**United Utilities Water Limited
Developer Services & Planning**
Warrington North WWTW
Barnard Street off Old Liverpool Road
Gatewarth Industrial Estate
Sankey Bridges
Warrington
WA5 1DS

Your ref: 3/2016/0296
Our ref: DC/16/1735
Date: 10-MAY-16

Location: 8 Hammond Drive, Read, BB12 7RE
Proposal: Erection of 2 detached dwellings

Drawing Title
Proposed Site Plan

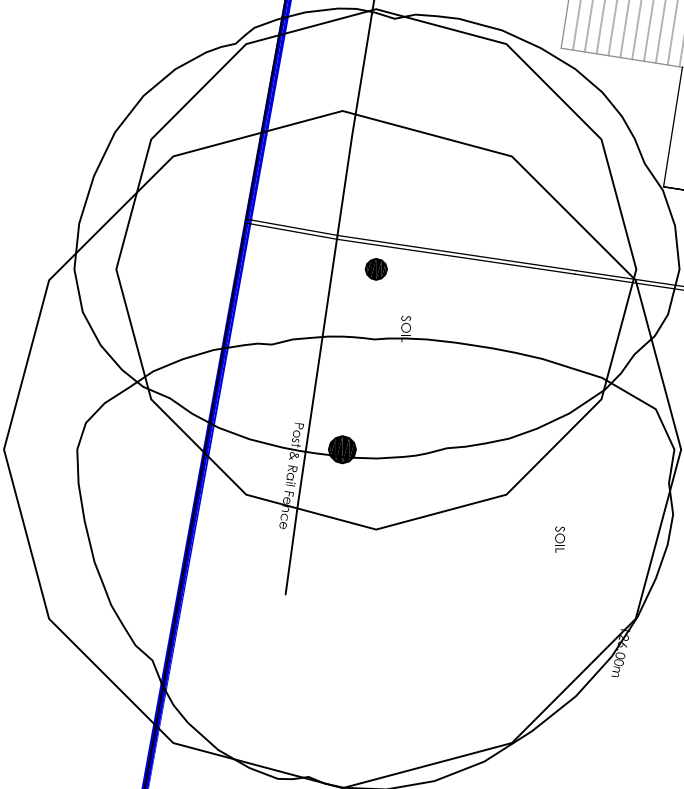
A public sewer crosses this site and we may not permit building over it. We will require an access strip width of six metres, three metres either side of the centre line of the sewer which is in accordance with the minimum distances specified in the current issue of "Sewers for Adoption", for maintenance or replacement. Therefore a modification of the site layout, or a diversion of the affected public sewer at the applicant's expense, may be necessary. To establish if a sewer diversion is feasible, the applicant must discuss this at an early stage with our Developer Engineer at wastewaterdeveloperservices@uuplc.co.uk as a lengthy lead in period may be required if a sewer diversion proves to be acceptable.

According to our records there is an easement (R274D dated 04/05/1900) that runs through the middle of the proposed development site. There is also an easement (R274A dated 04/05/1900) that runs along the boundary line of the development. Under no circumstances should anything be erected, planted or stored over the easement width, nor should anything occur that may affect the integrity of the pipe or United Utilities legal right to 24hr access. I would also advise that the developer adheres to the standard conditions for works adjacent to pipelines guidance and as there is a main sewer pipe crossing the site.
